**Subject: Environmental Impact Statement - NEXTDC S5 Data Centre and Innovation Hub (SSD-63168959)**

## **Attachment A – BCS comments on the Environmental Impact Statement - NEXTDC S5 Data Centre and Innovation Hub (SSD-63168959)**

APPENDIX 2 - TREE LOCATION PLAN

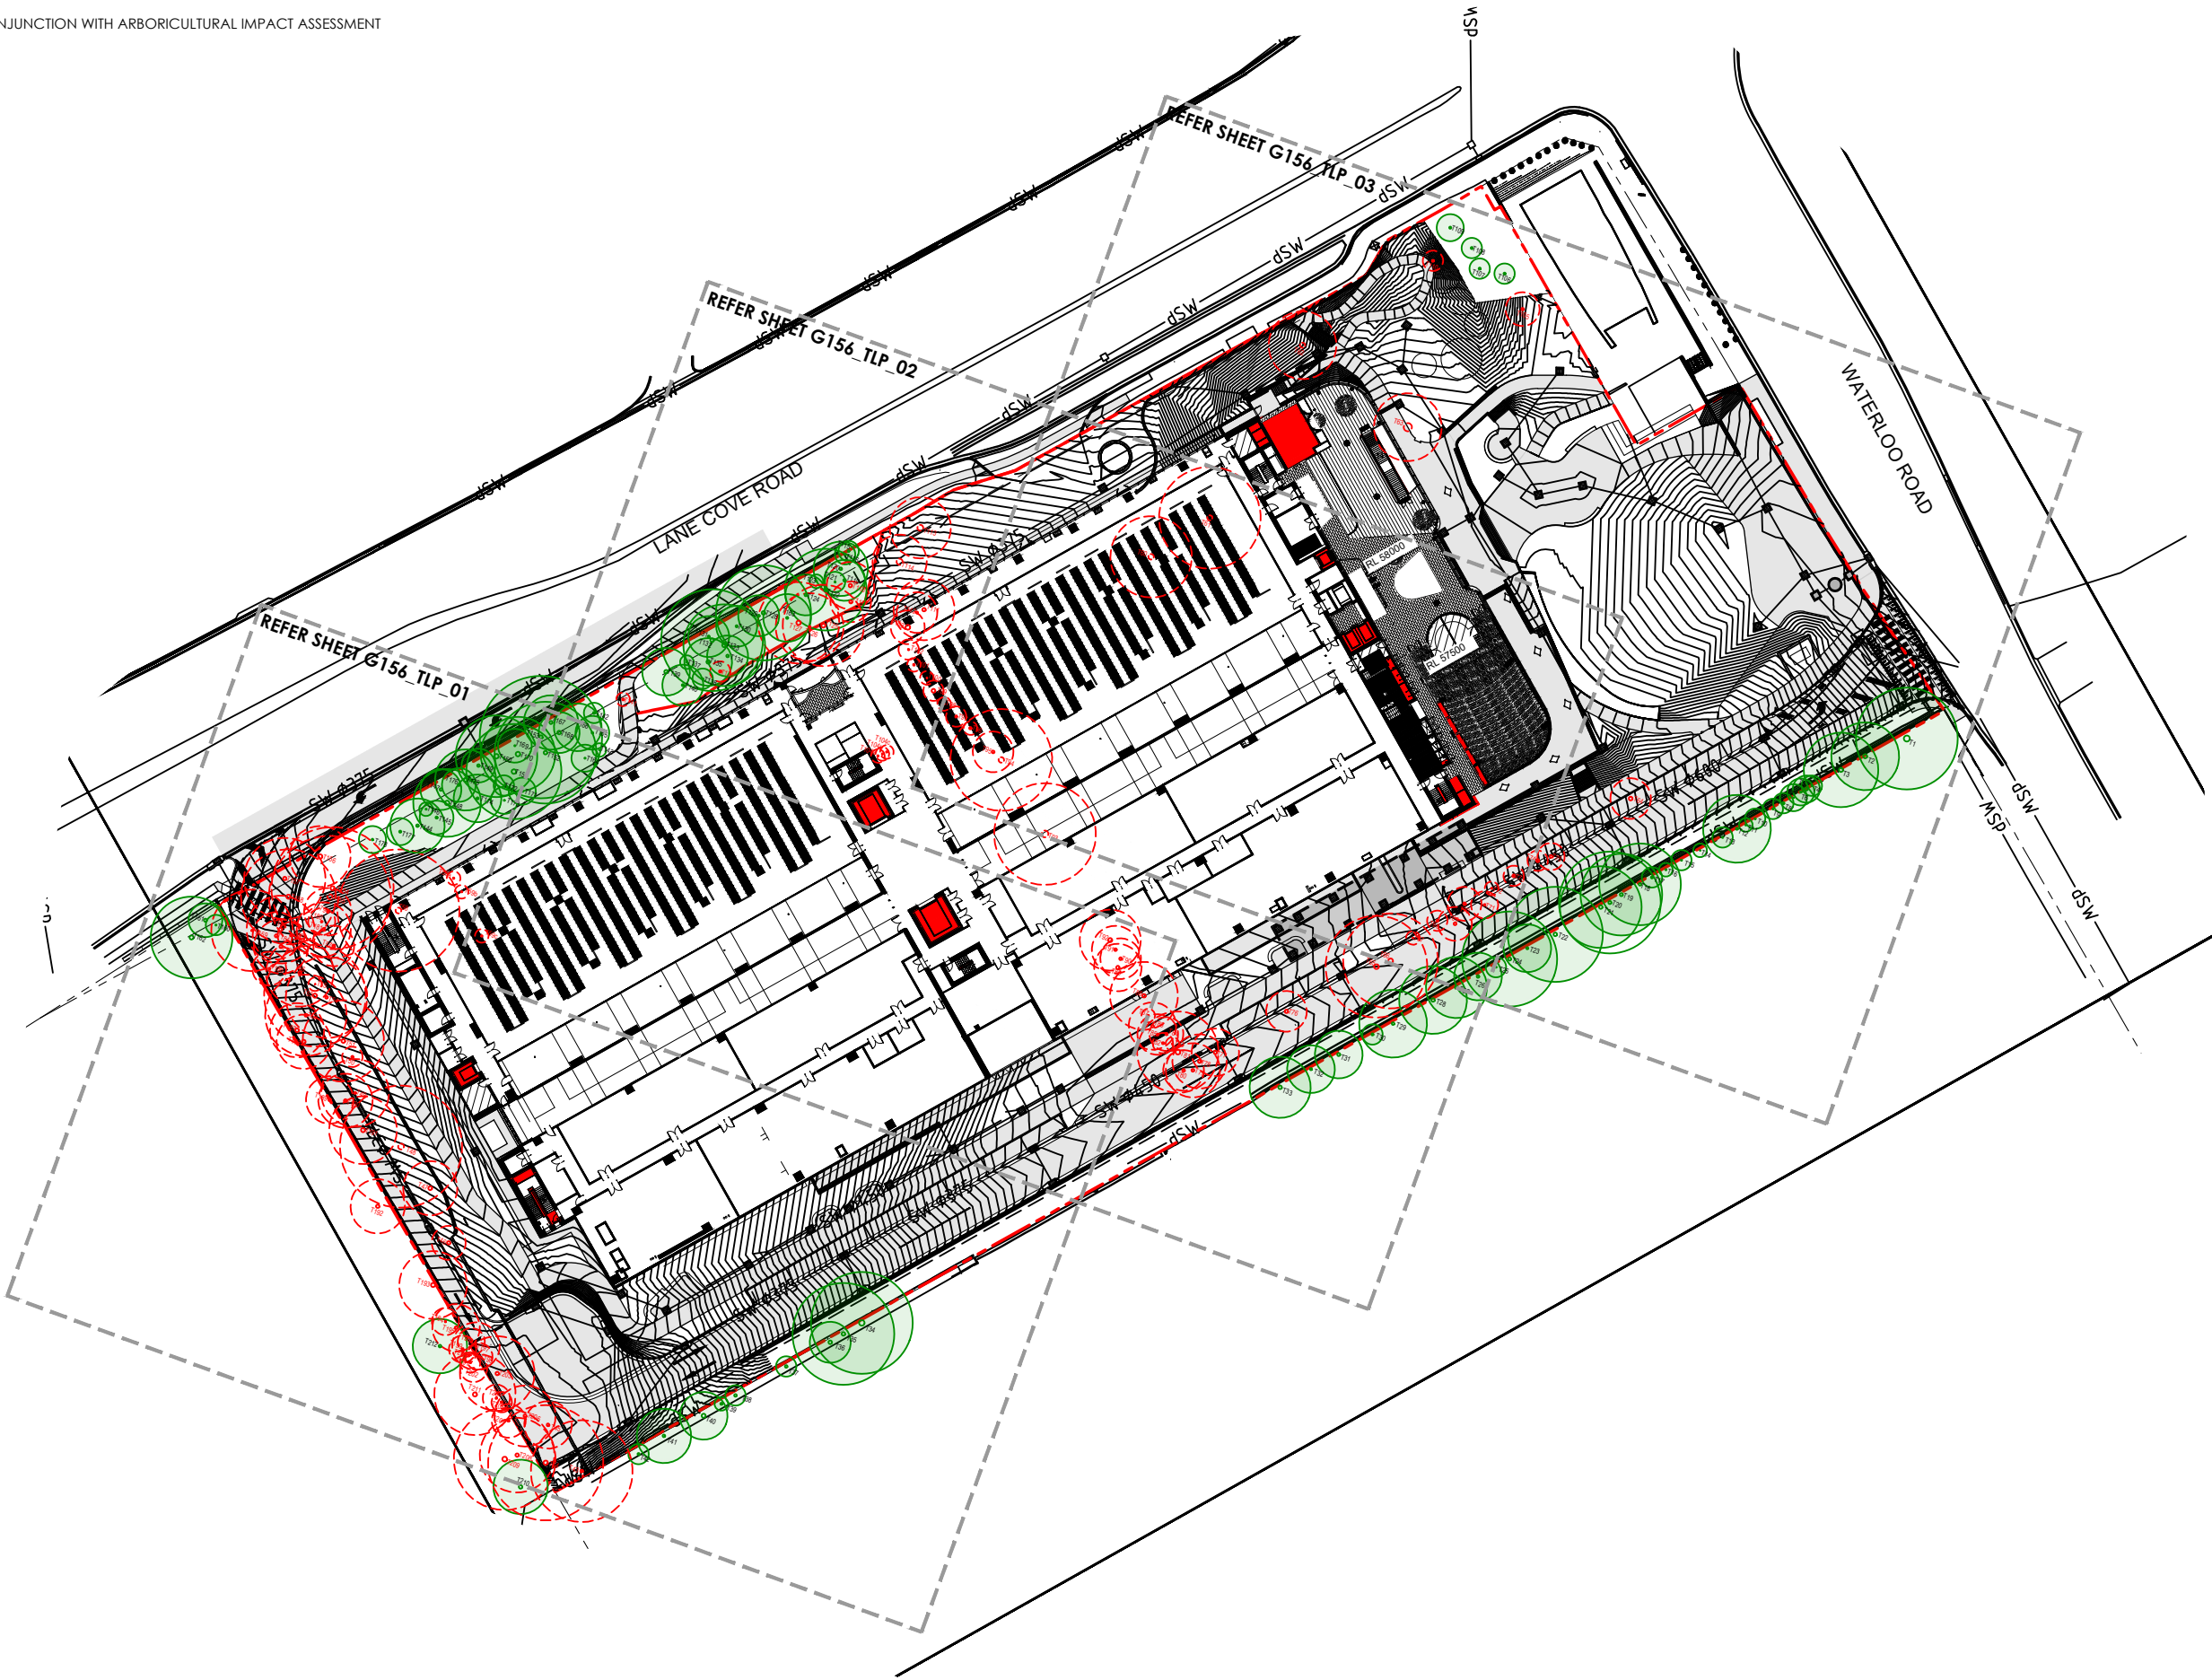
BCS considers that the Biodiversity Development Assessment Report (BDAR) adequately addresses the majority of the required streamline assessment criteria. The only section of concern is with proposed avoidance of the Critically Endangered Ecological Community (CEEC) Sydney Turpentine Ironbark Forest (STIF). The subject land is mapped to have 0.41ha of STIF, of which 0.35ha is proposed to be cleared, retaining 0.06ha.

For greater avoidance, it is recommended that a change in the dimensions of Building B be considered to have less impact on the south-west section of the site where the STIF is located.

If this is not feasible at this stage of the project, further justification / evidence is required to ensure the survival of the 0.06ha of STIF proposed to remain intact on the subject land. With the current information provided it is unlikely that the small, fragmented patch of STIF proposed to be retained will survive. This is due to the impacts given the high level of disturbance directly adjacent, the building envelope creating significantly more shading and an altered microclimate. If in perpetuity survival of the remnant 0.06ha of STIF cannot be adequately justified, an adjustment to the credits required is likely.
